Rezoning Petition Review

Rezoning Petition #: 20-125

Location of Property: Approximately 12.13 acres located along the southwest side of Back Creek Church RD, southeast of Hanberry Blvd and south of I-485.

**RZ-1.0**

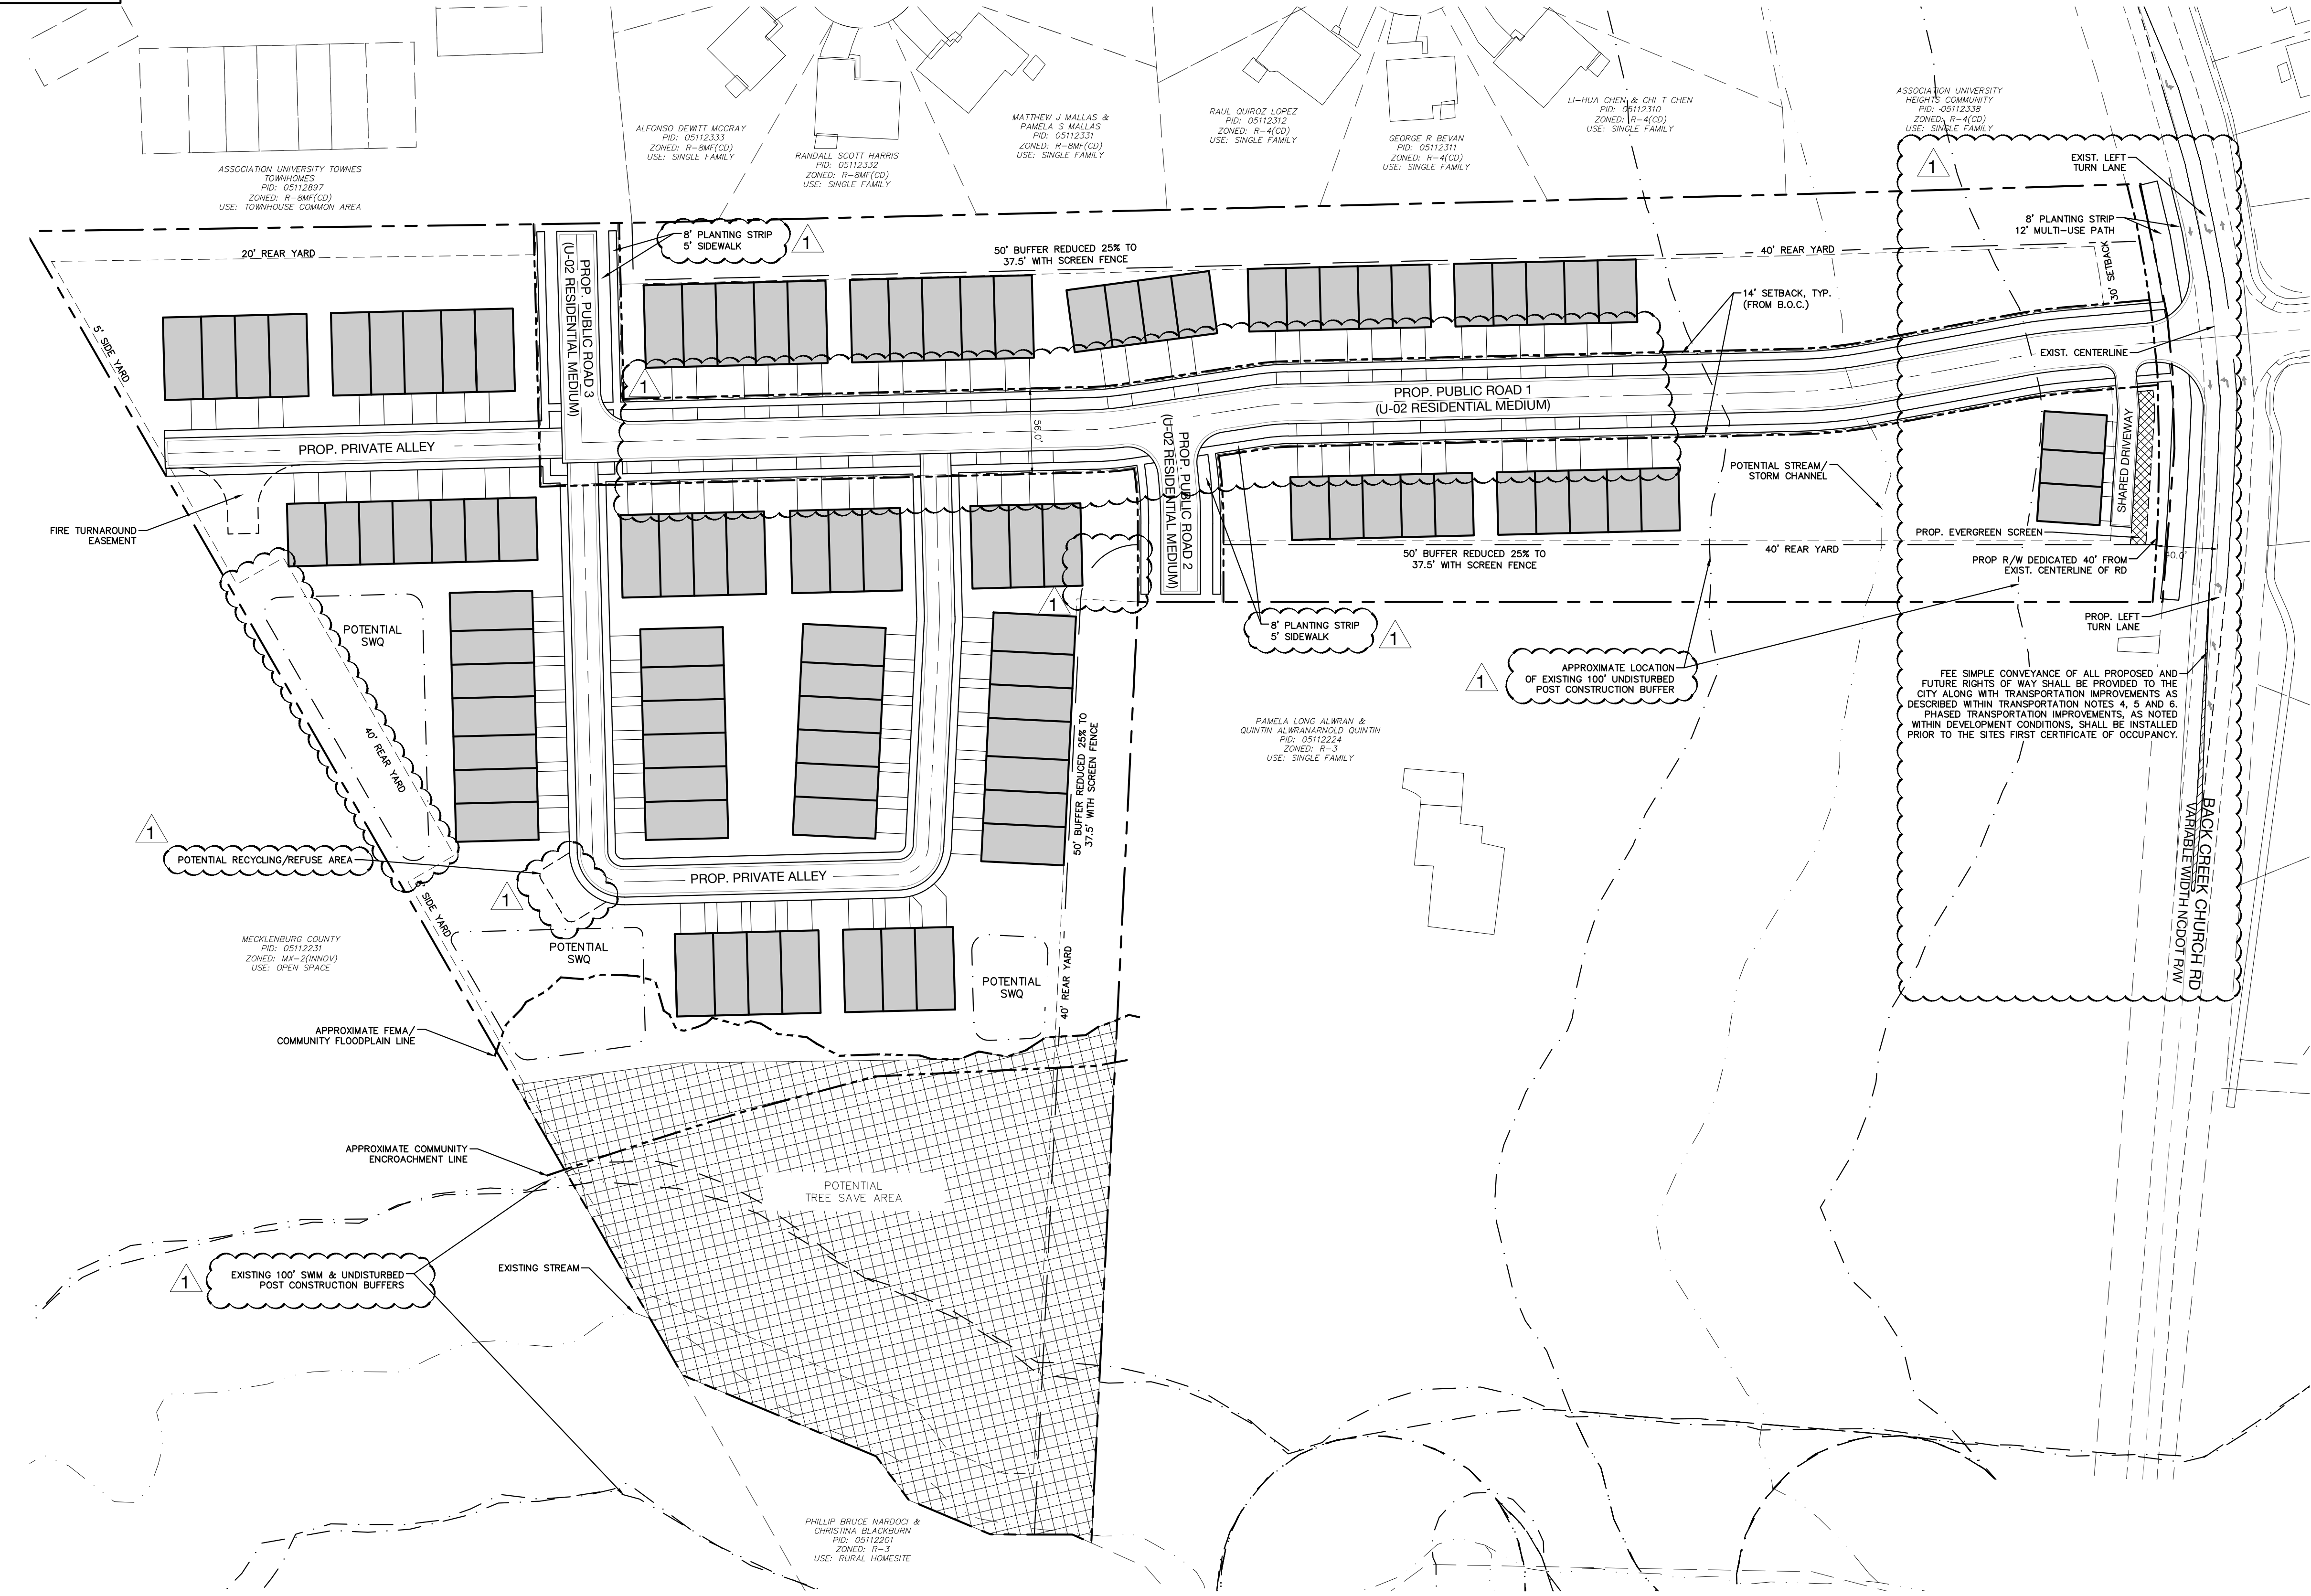
Please revise *“Existing 100’ SWIM/PCSO Buffers”* to read *“Existing 100’ Undisturbed SWIM/PCSO Buffers”*

The proposed rezoning plan sheet indicates a proposed location for storm water management. Please include the following notes on the plan sheet under “Environmental Features”:

- *The location, size, and type of storm water management systems depicted on the Rezoning Plan are subject to review and approval as part of the full development plan submittal and are not implicitly approved with this rezoning. Adjustments may be necessary in order to accommodate actual storm water treatment requirements and natural site discharge points.*
- *Development within any SWIM/PCSO Buffer shall be coordinated with and subject to approval by Charlotte-Mecklenburg Storm Water Services and mitigated if required by City ordinance. Petitioner acknowledges intermittent/perennial stream delineation reports are subject to review and approval upon submission of development plans for permitting and are not approved with rezoning decisions.*

Petitioner is advised the 100’ SWIM/PCSO Stream Buffers on the site may require the inclusion of 50% of the flood fringe area as additional stream buffer. Delineation of the additional stream buffer area may be deferred to the permitting process and is not required to be shown on the rezoning plan.
